Planning Application Ref: AW/125/20/T

Location: 229 Aldwick Road, Aldwick, PO21 3QG

Description of works: Re-pollard back to main stem to 1no. weeping willow tree

REF 1

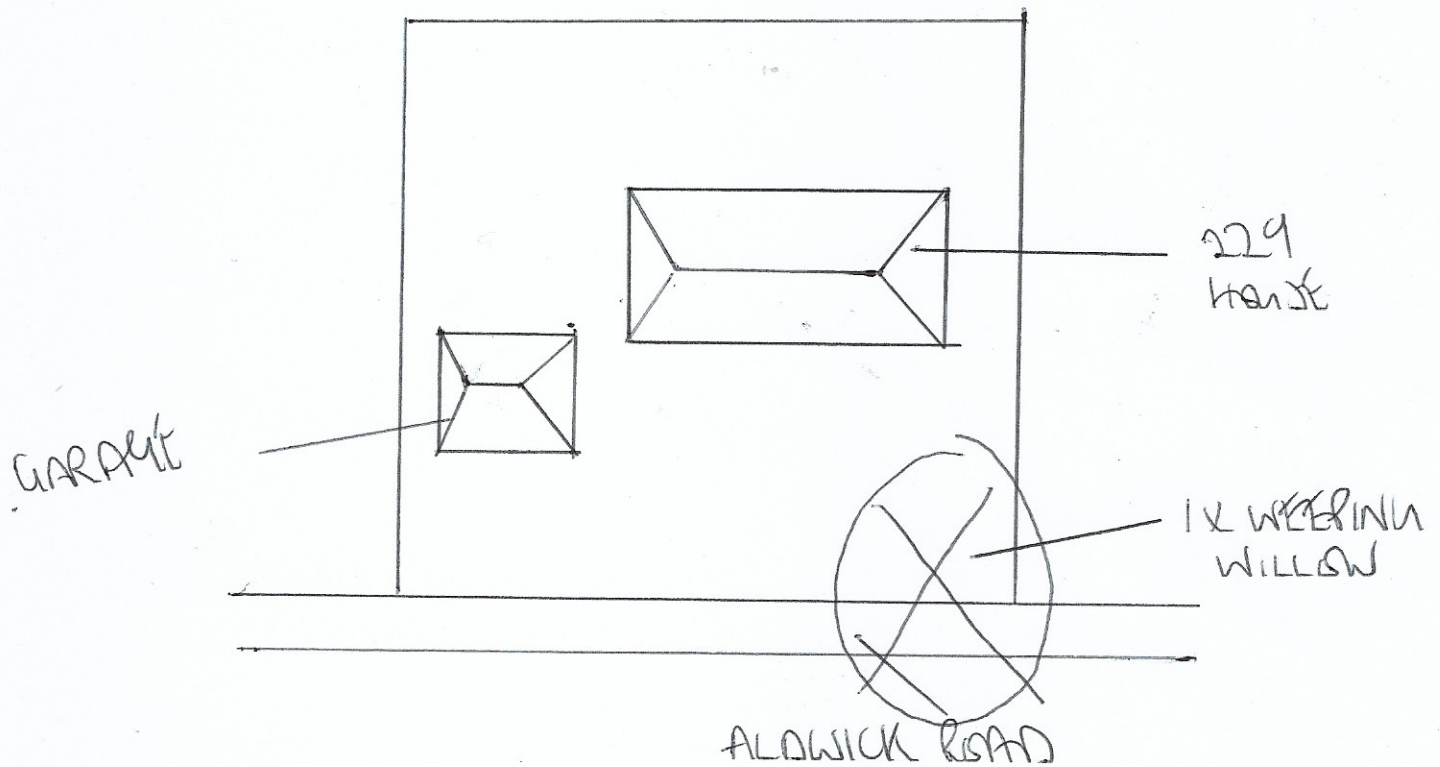
- Outwardly and from a distance this tree appears to be in a fine physiological state. Small cavities associated with historic pruning wounds suggest a degree of stem decay.

- It is highly visible from numerous properties and to users of the public highway (footway and carriageway). A 'pollarded' tree but crudely initiated with a 'topping out' of the main stem and severe truncation of limb framework. As such, the tree provides visual amenity only during the crown renewal/recovery stage. That has been vigorous since the last operation (c2012) and typical of a healthy example of its type, although asymmetric due to competing with willow trees on neighbouring property (recently re-pollarded).

- Repeat operations such as now being asked for by the applicant will be necessary throughout the remaining lifespan of this tree, to achieve a degree of structural integrity appropriate for its location.

- The proposal to reduce its overall height and spread with a view to restricting its growth is justified and consistent with previous works approved by the Local Planning Authority.
- While a temporary loss of aesthetic value is inevitable, satisfactory crown renewal and recovery should occur if the work is undertaken to a high standard and at an appropriate time of year.

- I recommend **CONSENT** for this application, subject to the following condition:

- Part a) Where whole branches are to be removed and final cuts made close to the trunk or branch union they are to be made as shown in Figure 2 of BS3998:2010
- Part b) Where branches are to be shortened back the final cuts are to be made at the correct angle shown in BS3998:2010 and adjacent to a live bud or lateral.
- Part c) The removal of crown material which has developed since the last operation must be done sympathetically and with respect to established 'knuckles' so as not to extend beyond the point of origin.

- The long-term vitality of this tree is best respected when significant pruning work such as proposed, is undertaken during the late-spring to summer period (May to August). The work proposed should only be undertaken during this period.
